PINS Reference TR050006 Northampton Gateway RFI

IP REF. SP074 - South Northamptonshire Council SNC ref 20190108/wr/ish2-3

Date – 8 January 2019

South Northamptonshire Council – Written Submission pursuant to ISH 3.

Figure 8.1 Receptor locations for noise and vibration assessment – Around Main Site

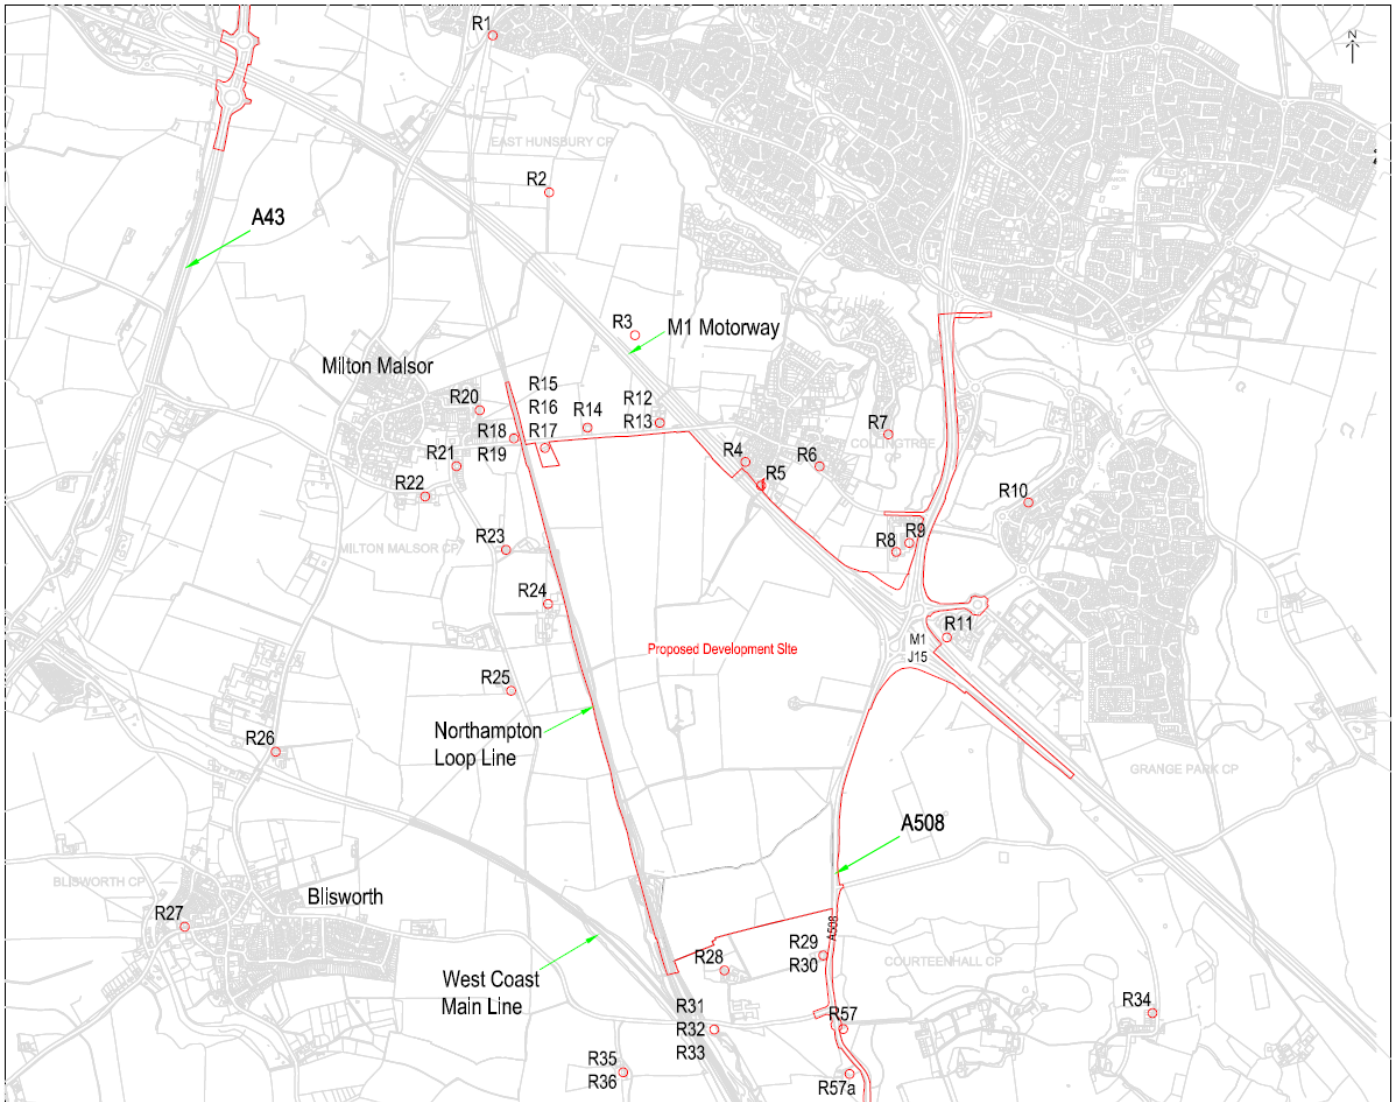
- Road Traffic Noise Around Main Site:- No adverse comment but point I raised was that no consideration appears to have been given any mitigation for Receptor R29? Also, whether further efforts could be made to reduce the significance of temporary significant adverse impacts predicted for Receptors R27, R31 to R33 in respect of the provision of temporary screening (see Section 3.3 of my Review Note for more detail)?

In respect of the predicted significant adverse impacts, what happens if some of the assumptions do not materialise as expected?

I am concerned regarding the three exception locations when in 2043 it is predicted there could just be a significant adverse effect due to a possible increase of one noise induced awakening a night in that scenario (i.e. R1 Woodpecker Way, R18 Collingtree Road North, and & R54 Ashton Road W). I am not clear what exceedance value they have used but The World Health Organisation Guidelines recommends a limit for individual noise events not exceeding an L_{Amax} 45 dB and guidance of which has been further supplemented by the WHO Night Noise Guidelines for Europe where it comments that effects have been observed at 45 dB or less". Furthermore, in the noise hierarchy detailed in the Planning Practice Guidance its states that significant adverse effects should be "avoided" if not "prevented" depending whether the level of intrusion is noticeable and disruptive or very noticeable and disruptive. The acoustic metric test used for individual noise events is different than the one covered under provisions of the Sound Insulation Regulation for Railways but equally important since the WHO comment in its Night Noise Guidelines for Europe that "if the noise is not continuous, sleep disturbance correlates best with the L_{Amax} ...". The consultant's conclusions are based on a number of assumptions which involves a degree of uncertainty. Given the degree of uncertainty involved in this instance is it possible to extend the context of the exception to include an offer of protection to the occupiers of those three properties and which may only require the provision of suitable glazing and alternative means of ventilation?
